December 13, 2023

City of Albuquerque Planning Department  
Mr. James D. Hughes, P.E.  
600 2<sup>nd</sup> Street NW  
Albuquerque, NM 87102

We have received your comments on the Erosion Control Permit (ECP) for the Calle Cuarta Residential Subdivision. Our response to each item listed in the letter date December 6, 2023 follows.

CALLE CUARTA LIMITED
 PARTNERSHIP, LLLP
 CALLE CUARTA
 TESCP

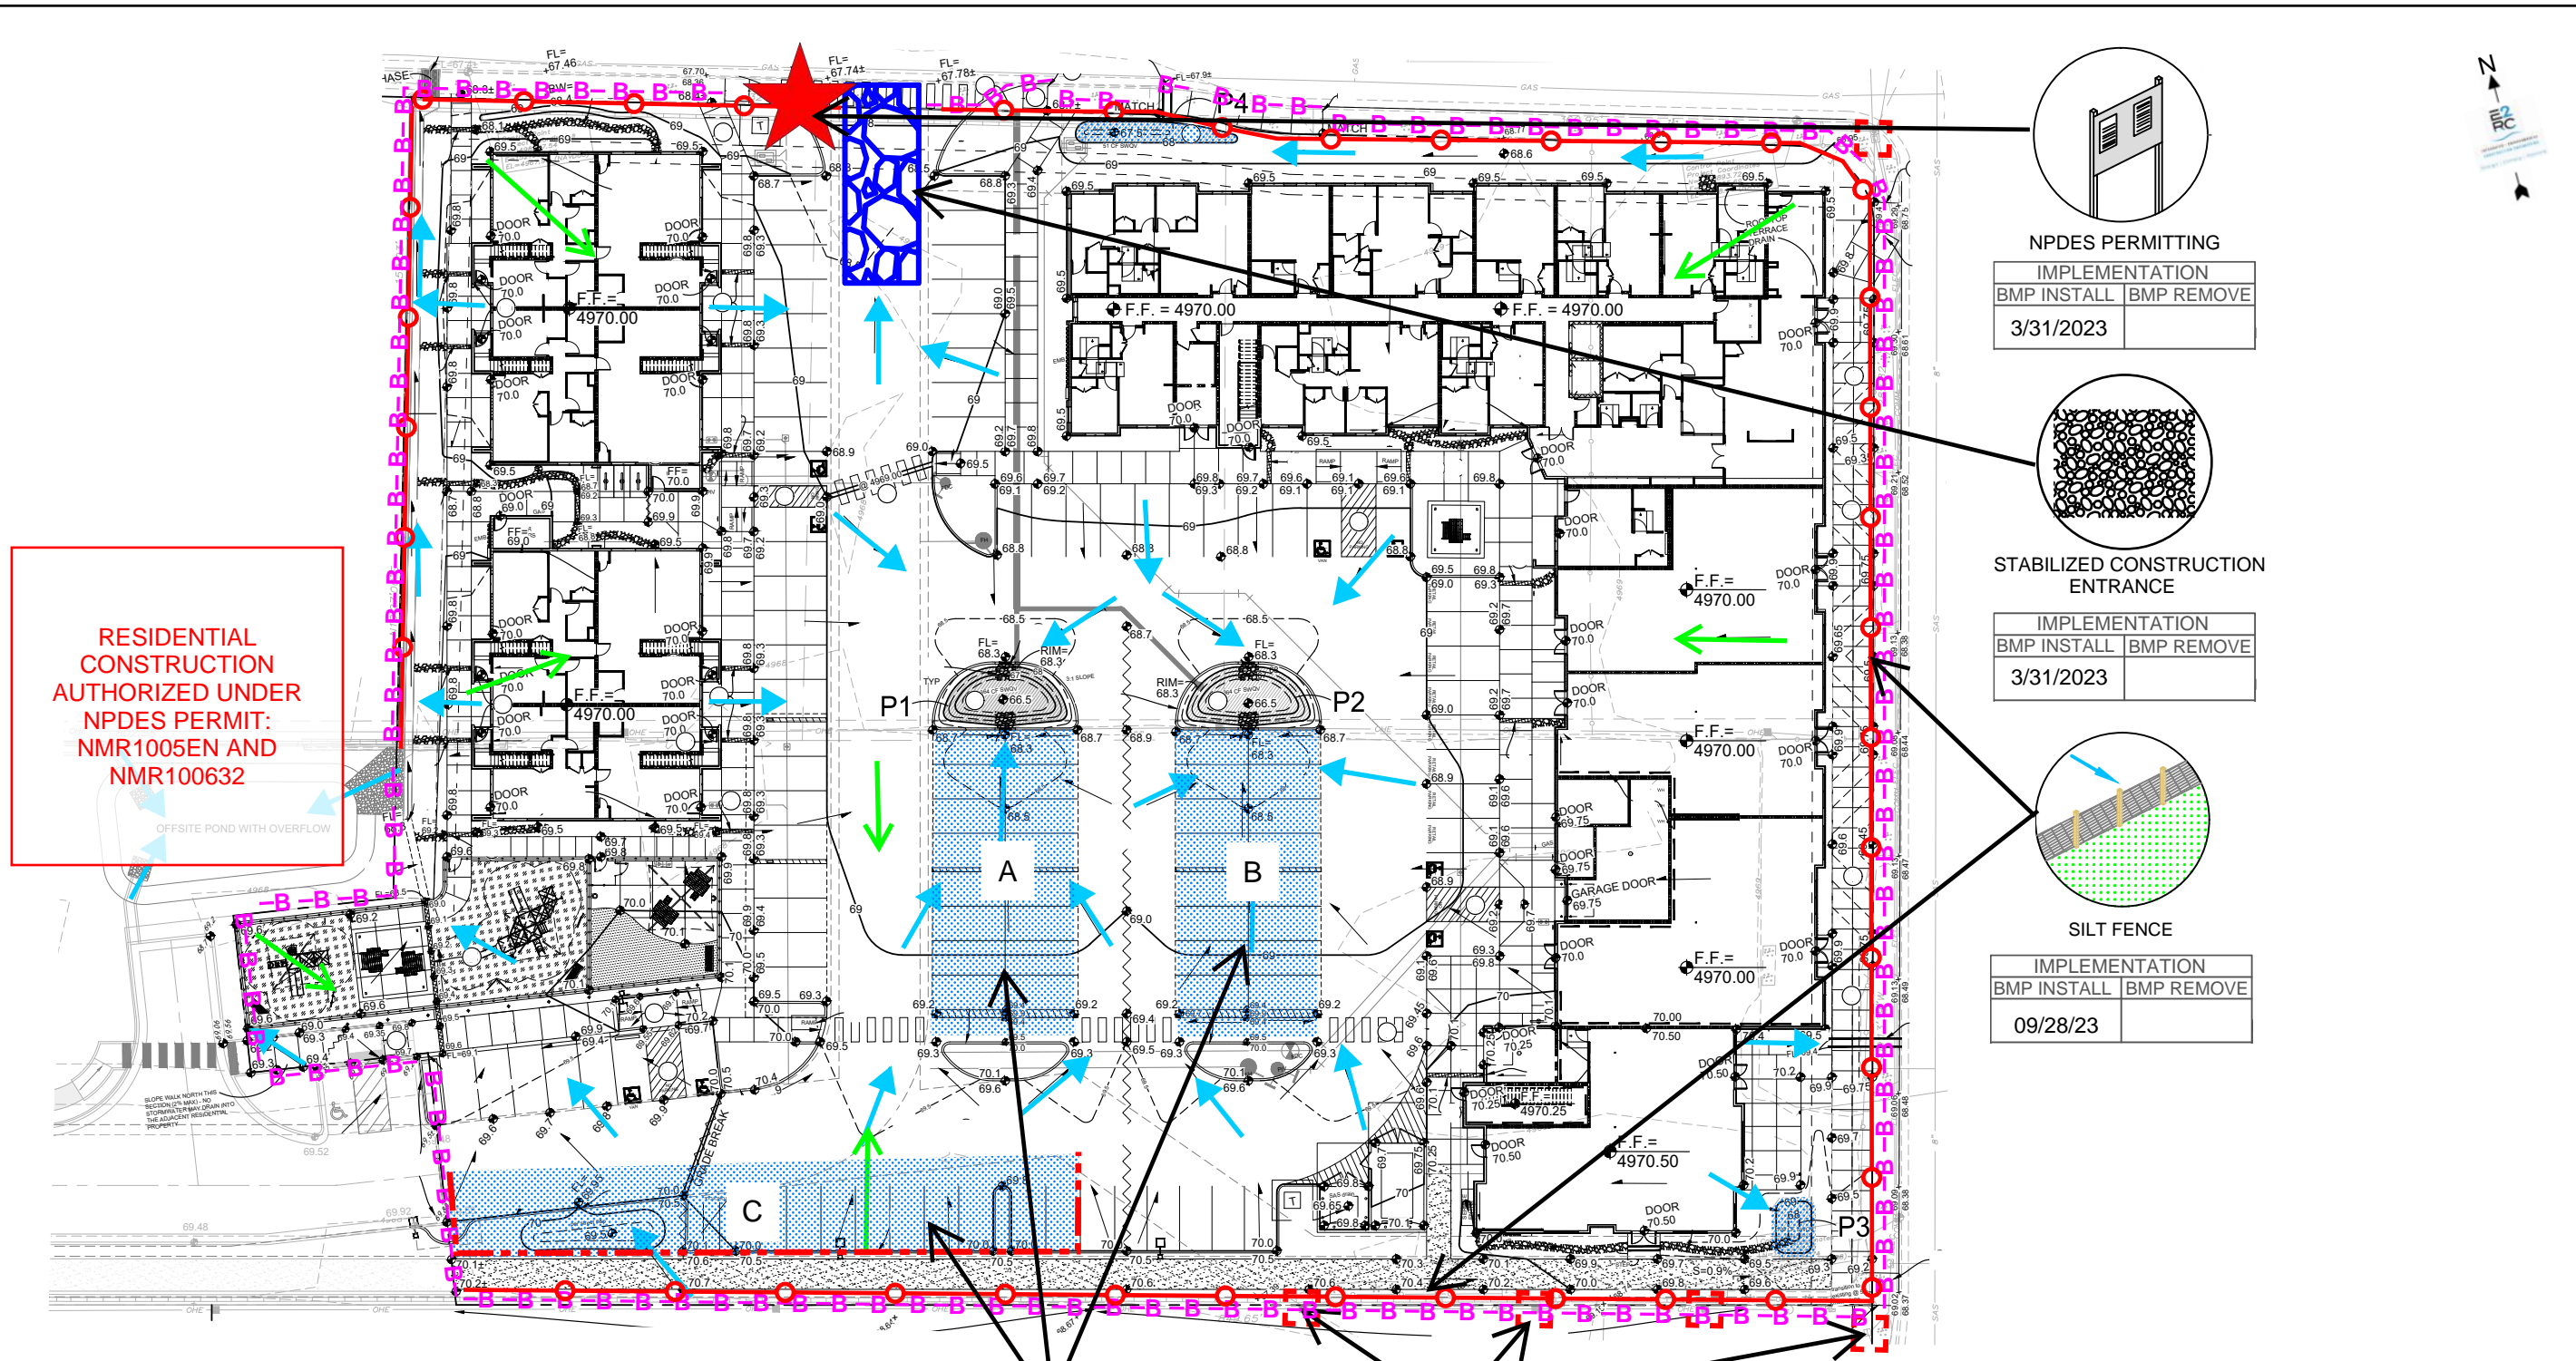
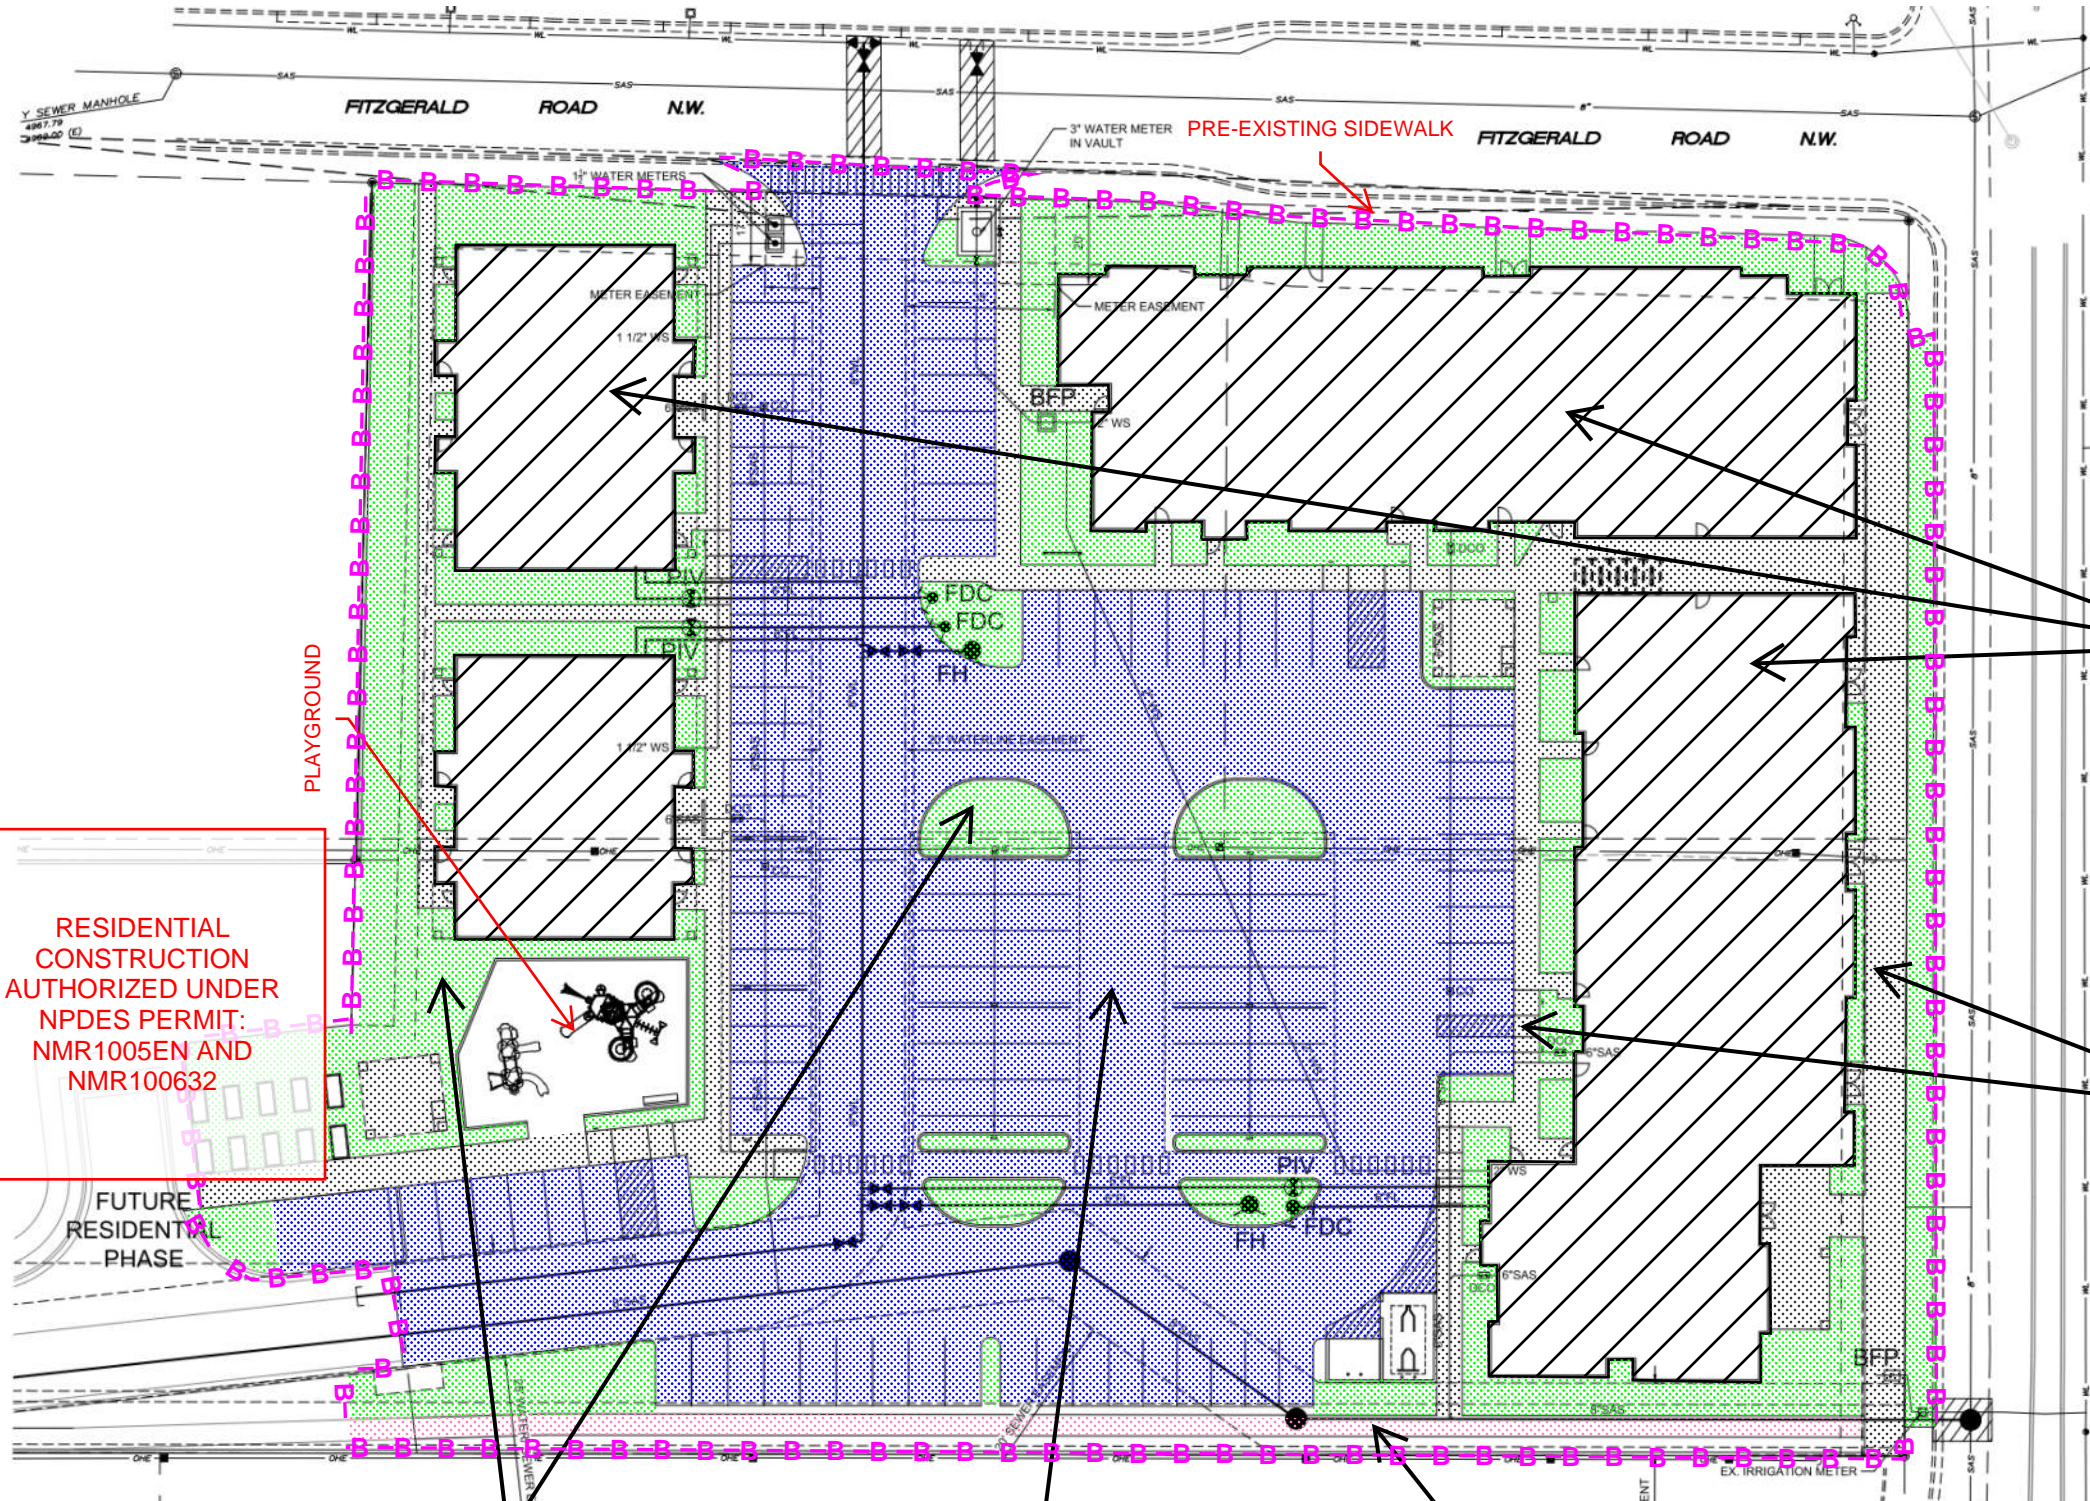
4. Sheet numbers were added.
5. The City Standard Notes have been updated.
6. We have sized and located the sediment basins on the drawing. The supporting calculations are enclosed.

YES CALLE CUARTA TH, LLC
CALLE CUARTA RESIDENTIAL
SUBDIVISION
TESCP - PWO

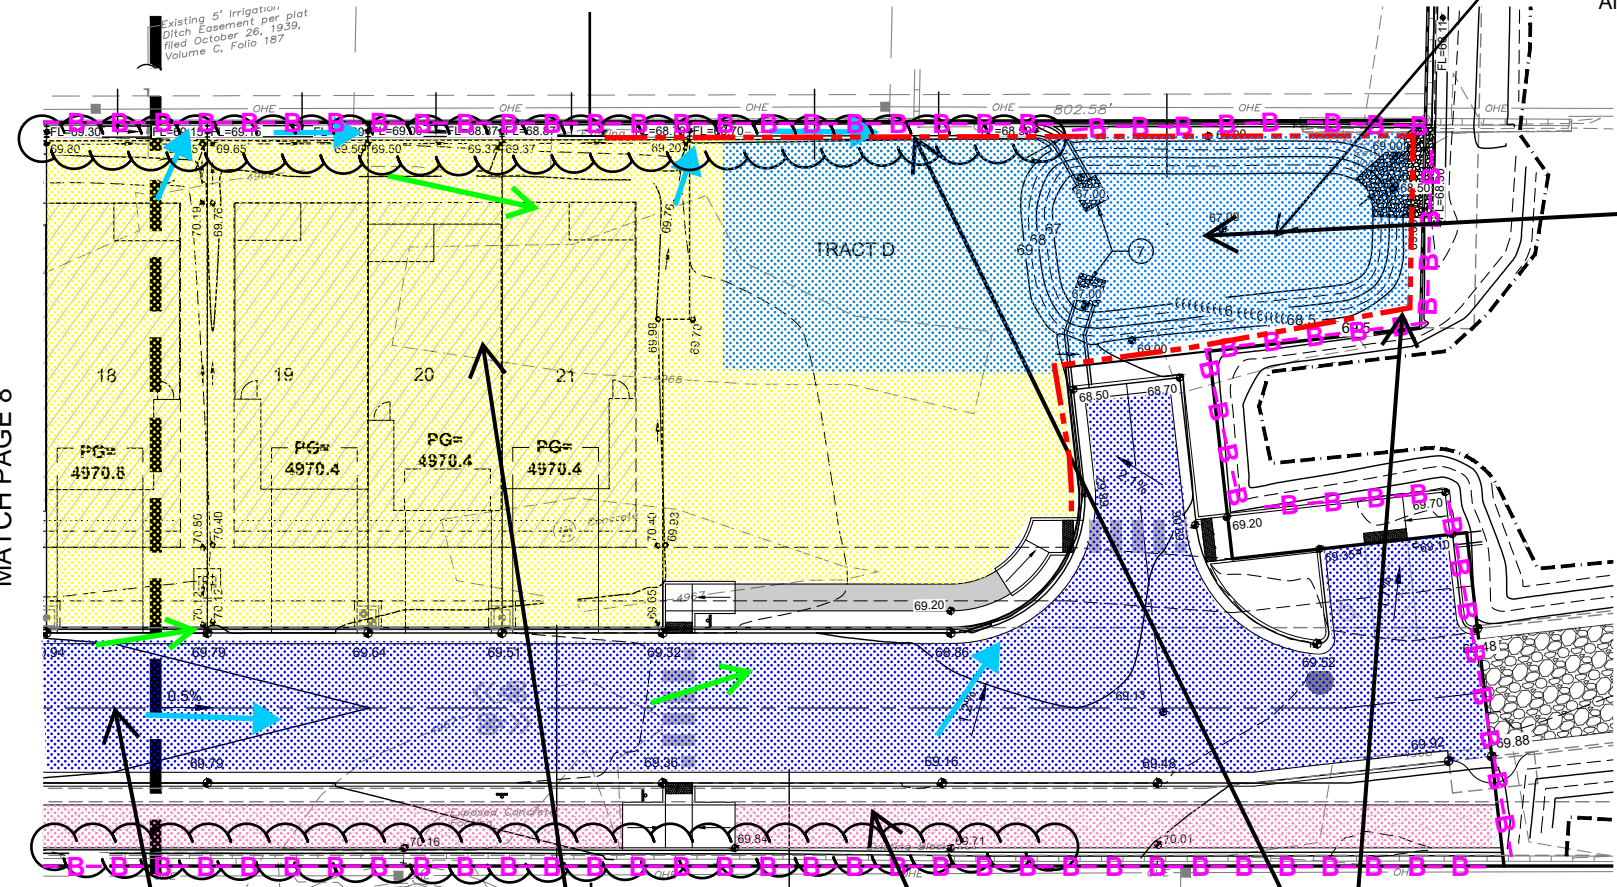
2. The original Erosion Control Drawing (ECD) has been changed to create two ECD, one for the residential subdivision and a second for the apartments.
3. As of today, Yes Housing TH, LLC has not identified a builder for the townhomes. The owner expects it will begin selling the parcels in February. We kept the note on the ECD notifying the owner that each homebuilder, if more than one, is required to pursue and submit separate permitting as part of the CGP requirements for a common plan of development. We note the permanent stabilization that will be constructed and advise of the temporary stabilization requirements for the individual lots. Finally, the phasing on page 2 was modified to address the temporary final stabilization.
